EPC STORMWATER REVIEW COMMENTS  
IN ORANGE BOXES WITH BLACK TEXT

## FINAL DRAINAGE REPORT

### MAYBERRY, COLORADO SPRINGS – FILING NO. 2A

SEPTEMBER 2023

FILING 2A PROP.
DRAINAGE MAP

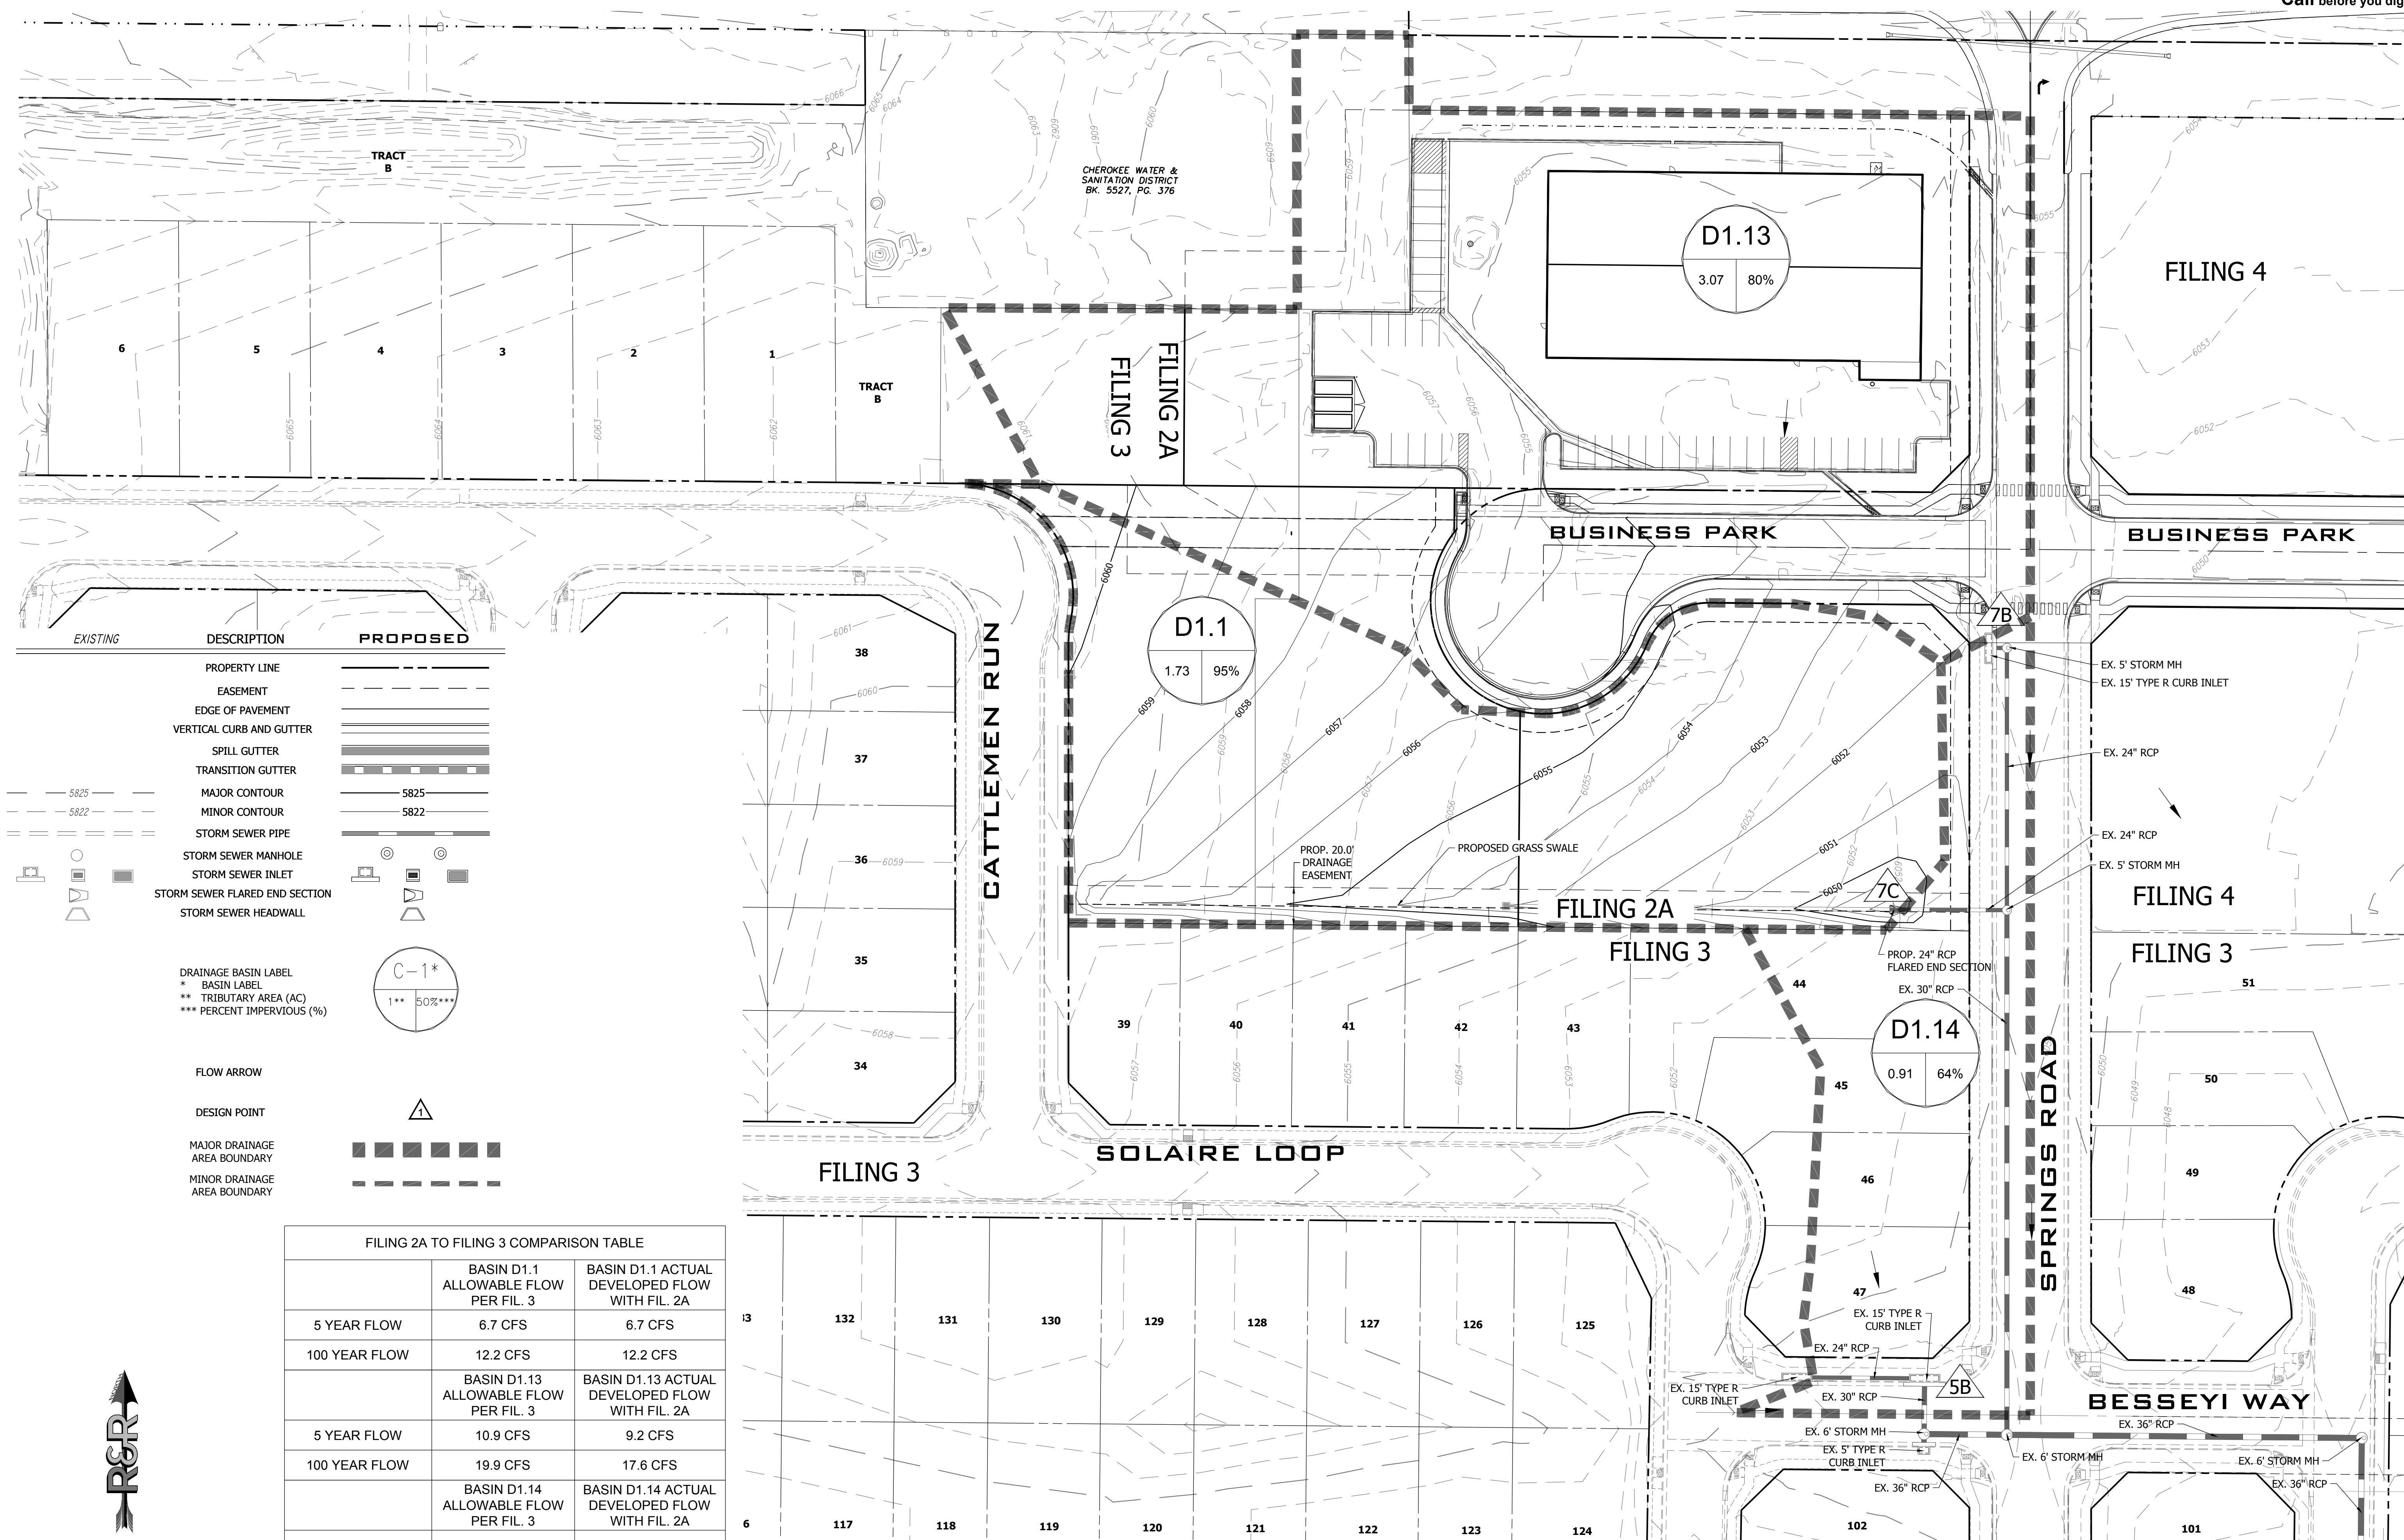
Engineer must confirm in the Drainage Report that the existing offsite or onsite PBMPs that the site is tributary to are functioning as intended. Provide design calcs and verify that the existing pond was designed to accept the proposed flows.

The approved routing spreadsheets and drainage maps with Filing 3 FDR has been provided in the appendices within this report. For clarity, the MHFD spreadsheet has been included as well to show that the pond designed within Filing 3 is adequately sized to treat and store Filing 2A runoff.
